Our Case Number: ABP-316828-23

Re: Tallaght/Clondalkin to City Centre BusConnect Core Bus Corridor Scheme.
Tallaght/Clondalkin to Dublin City.

PLANNING RESPONSE

Submission on the proposed
construction of the Tallaght /
Clondalkin to City Centre Core Bus
Corridor

C:\users\costello\appdata\local\projectwise\workdir\mot-sg-pw-c03\02528893\BCIDA-ACM-STR_GA-0008_BR_03-DR-CB-0102.dwg

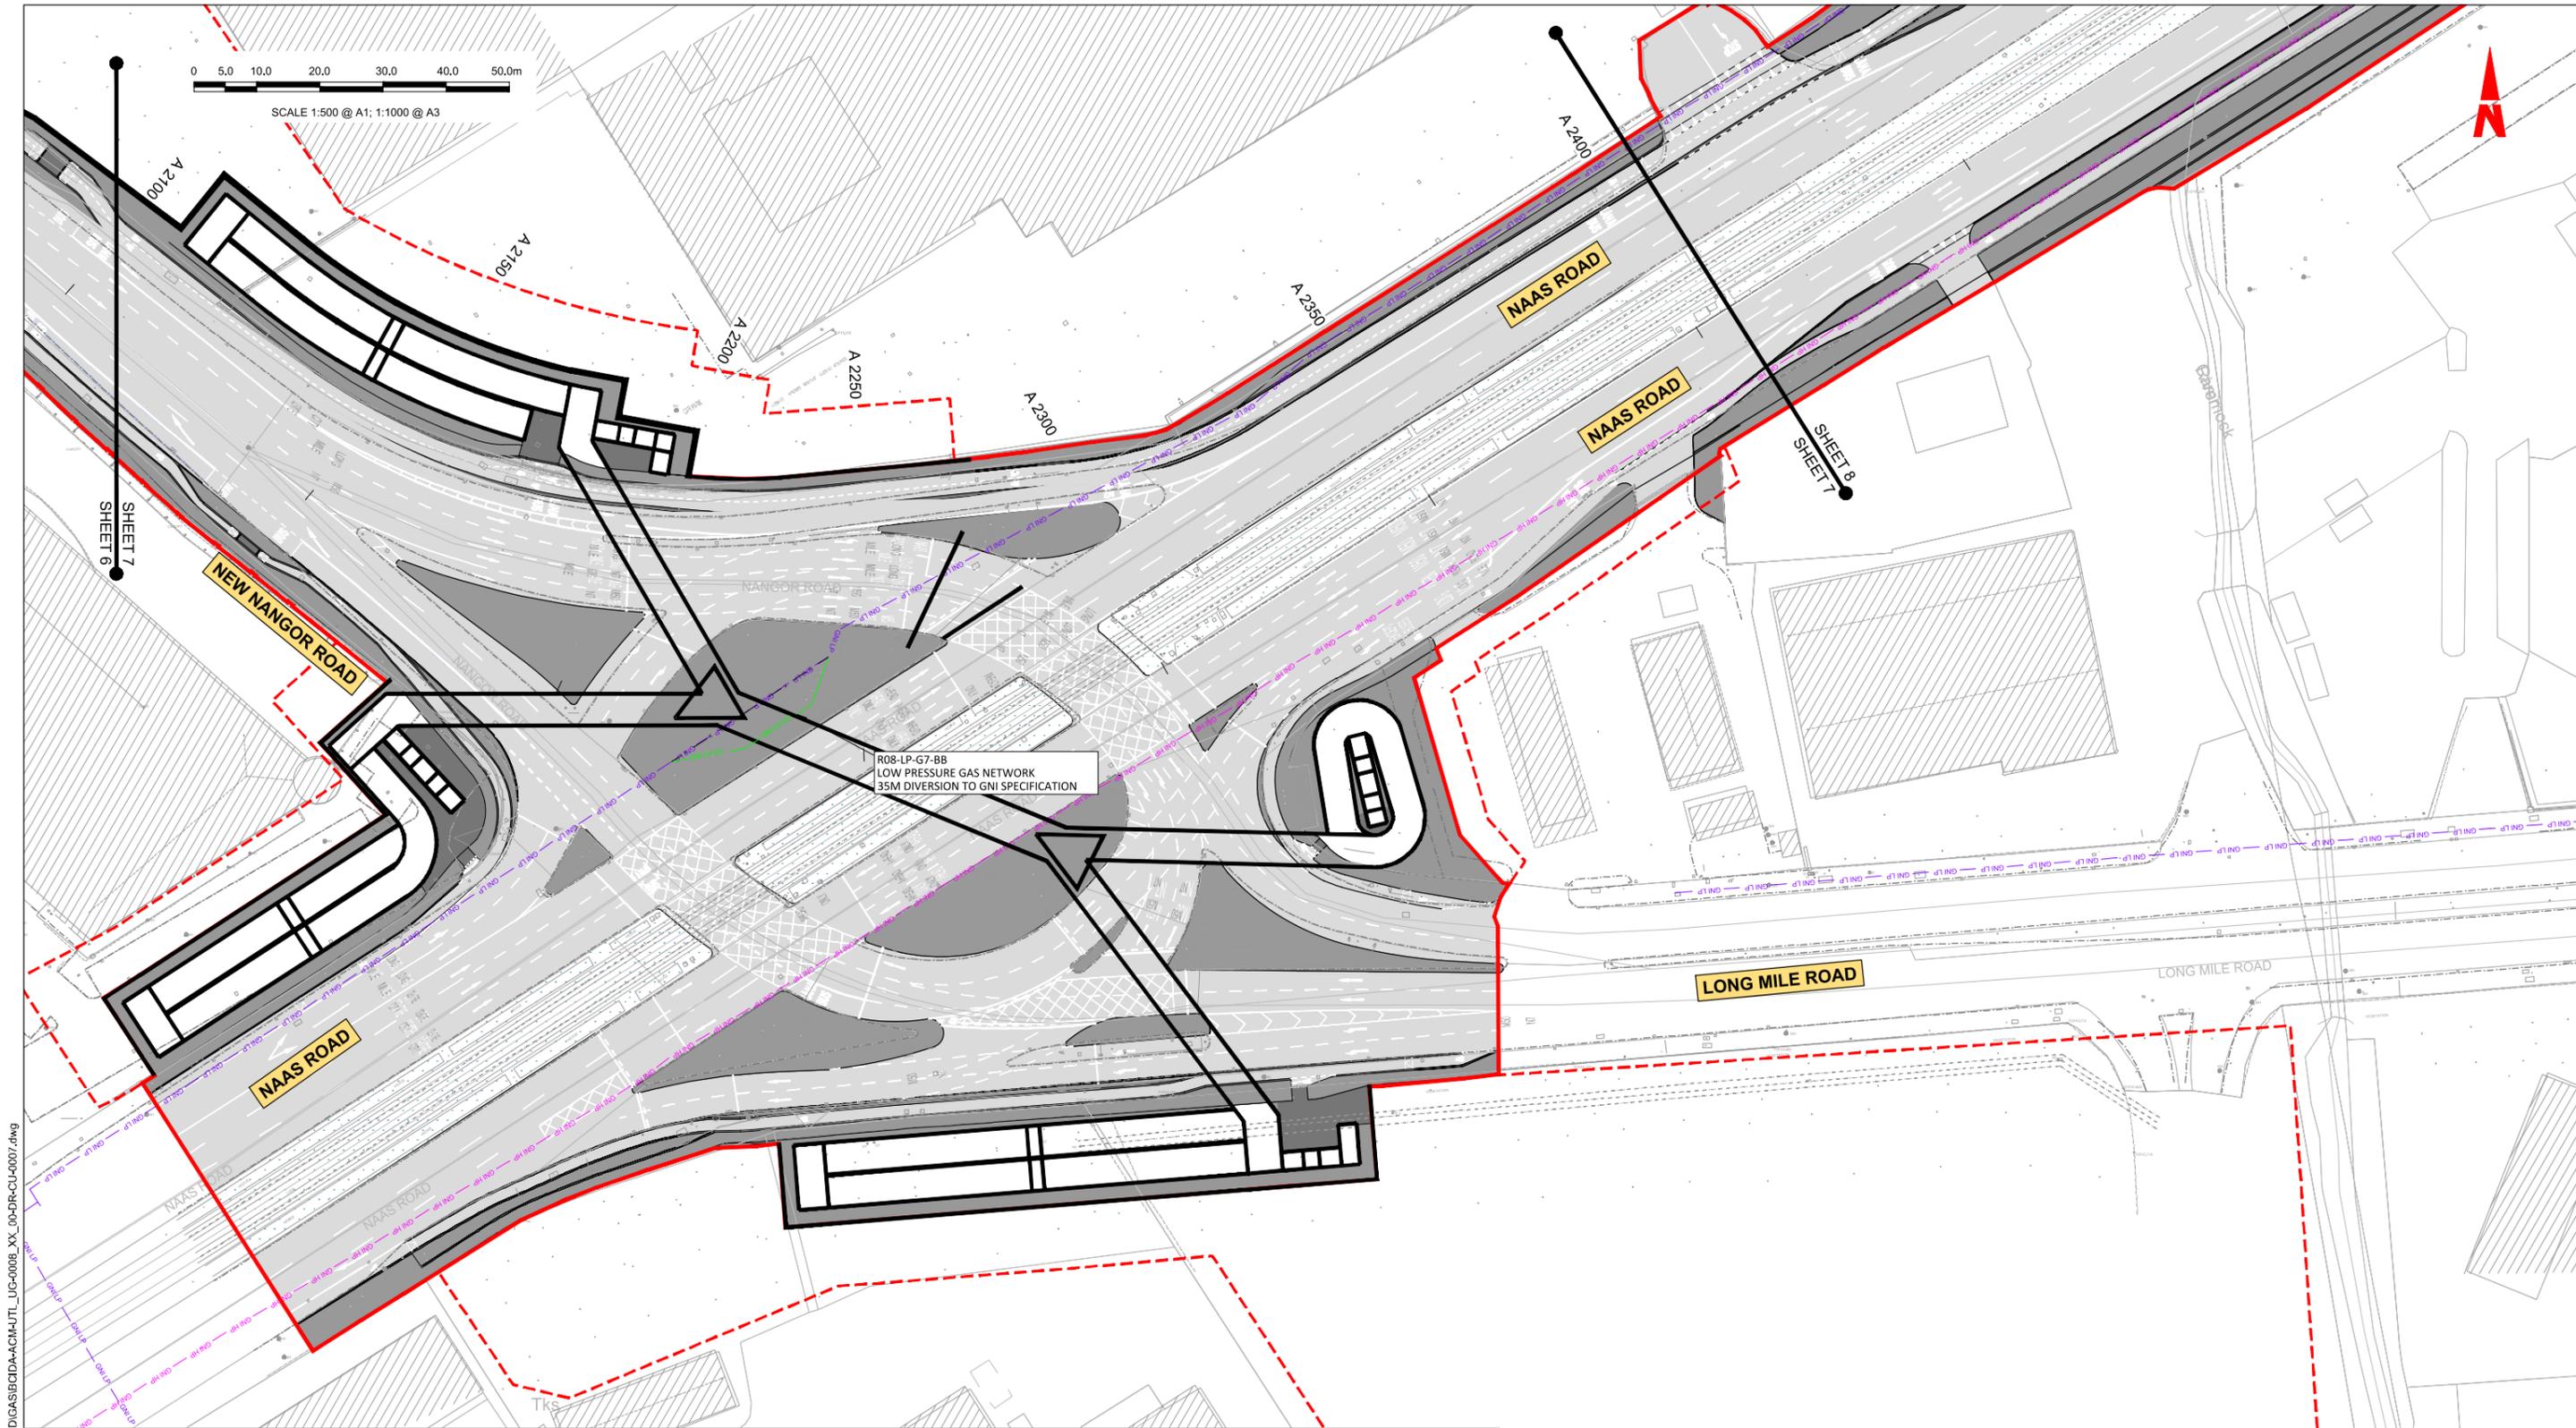
3.3 The design as envisaged leaves a narrow access lane (6 metre access road for vehicles reversing) which is situated between the footbridge ramp and the façade of the Woodies building. This access lane is not enough to allow vehicles to turn and turning will be necessary in the customer car park to the front of the store. This will result in the loss of car parking spaces and an unsafe practice of turning of delivery vehicles in a customer car park area where pedestrian movements occur. The NTA alternative proposal for delivery vehicle access is unworkable and the widths proposed are inadequate.

streetscape, the more serious impact will be in views from the southeast of the junction as the ramps to the footbridge are directly placed in front of the façade of the Woodies building facing the Naas Road.

negative way by the proposed footbridge with accompanying ramps as is clearly illustrated in the figure shown. It is considered that the proposed pedestrian Bridge and Bridge Ramp will impinge on the visibility of the Woodies and EZ Living buildings and the visual quality of these buildings and surrounding streetscape of the Naas road corridor into Dublin City.

5.3 The response by the NTA focuses exclusively on the glazed panels facing the Nangor Road frontage and fails to refer to the large area of laminated shop front façade on the Naas Road (south eastern) frontage of the building. The footbridge and ramps structures will be close to this façade. While the bridge spans may be fully enclosed it is not clear whether this is also the case for the ramps to the footbridge. Concerns remain about the potential impact of the bridge and ramp structure in front of the Woodies store building in terms of vandalism and anti-social behaviour.

6.3 It is relevant to note that the temporary land acquisition comprises a narrow strip of land between the proposed retaining wall and the existing façade of the Woodies building. Concerns remain that the

proposed temporary land acquisition area may not be adequate for safe access & egress, plus site operations, without further encroachment on land surrounding the Woodies building.

7.3 While it is acknowledged that the junction is a complex road junction, it should be noted that the proposed bridge structure would require cyclists to following the ramp structures resulting in a significantly longer distance plus need to cycle up the slope of the ramps. In practice, it is unlikely that cyclists would follow this route and it is more likely they will prefer to follow existing routes along the road using crossing points at different locations around the road junction. Pedestrians also tend to prefer direct desire lines rather than footbridge routes which require longer walking distances along the ramp structures. It is not accepted that the traffic light arrangements necessarily need to result in long delays for pedestrians and cyclists if the traffic lights give equal priority to cars and HGVs vs. pedestrians and cyclists or even preferential treatment for the slow traffic modes. There is a

significant risk that the footbridge will become a ‘white elephant’ and it is noted that elsewhere in the city well intended footbridges tend to be removed in favour of traffic light arrangements.
